From: Robert Findlay
Sent: 13 May 2014 16:04
To: Planning.Responses
Subject: FW: Planning Consultation on: AL/26/14/PL

Regarding the Cart Barn.

Description of Works: Change of use from 5 no. tourist units to 5No. residential units
(C3 Dwelling).

FLOOR PLAN 1:50
CART BARN

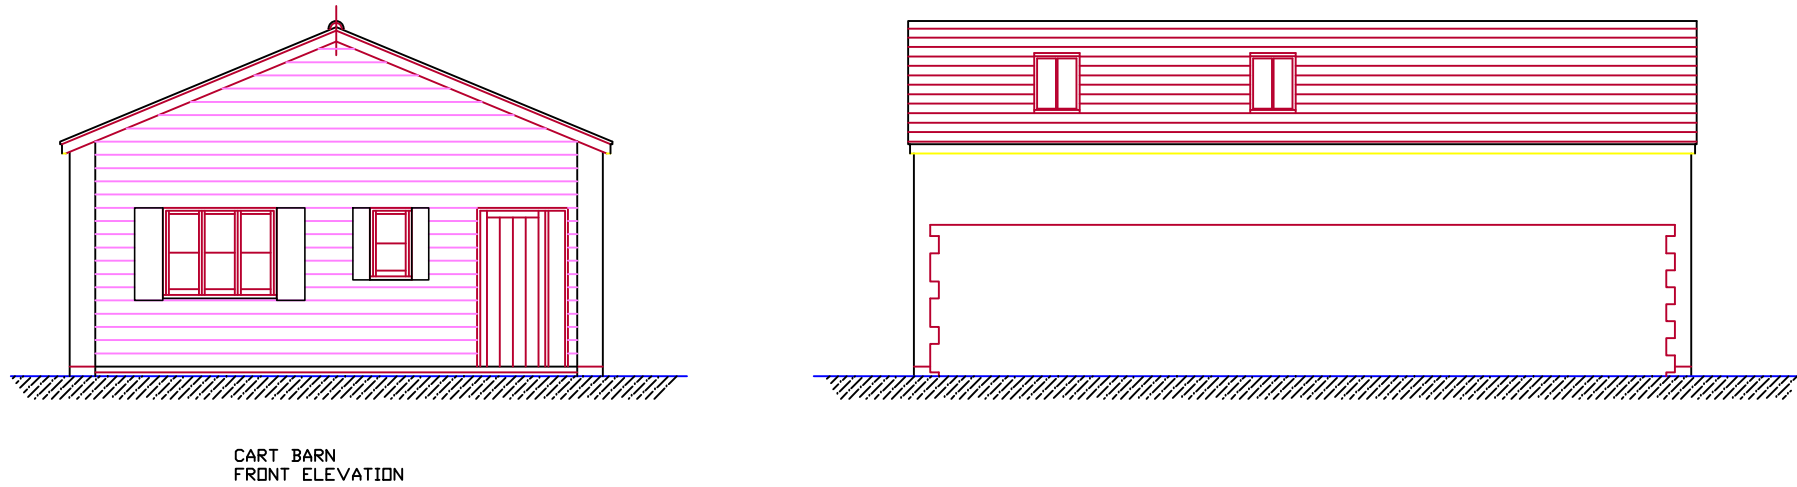
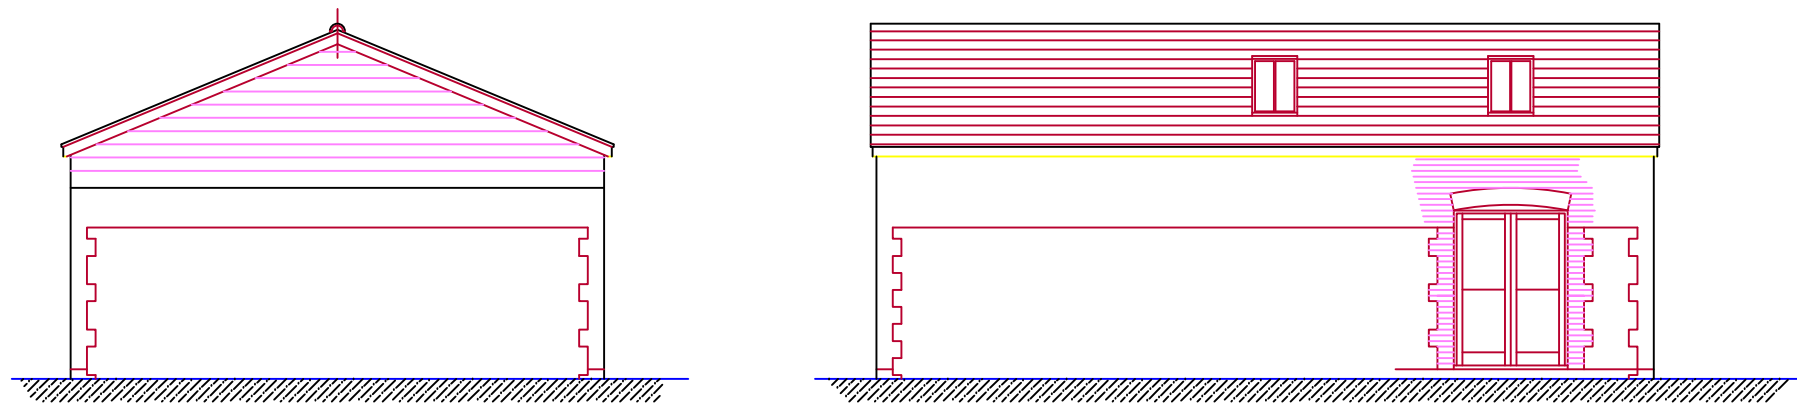
There are concerns regarding natural lighting and ventilation.

Natural ventilation is to be provided by openable windows in each habitable room with the openable part of the window equivalent in size to 1/20th of the available floor area without utilising openable doors.

Natural lighting to be provided by windows and glazed doors with a glazed area equivalent to 1/10th of the available floor area
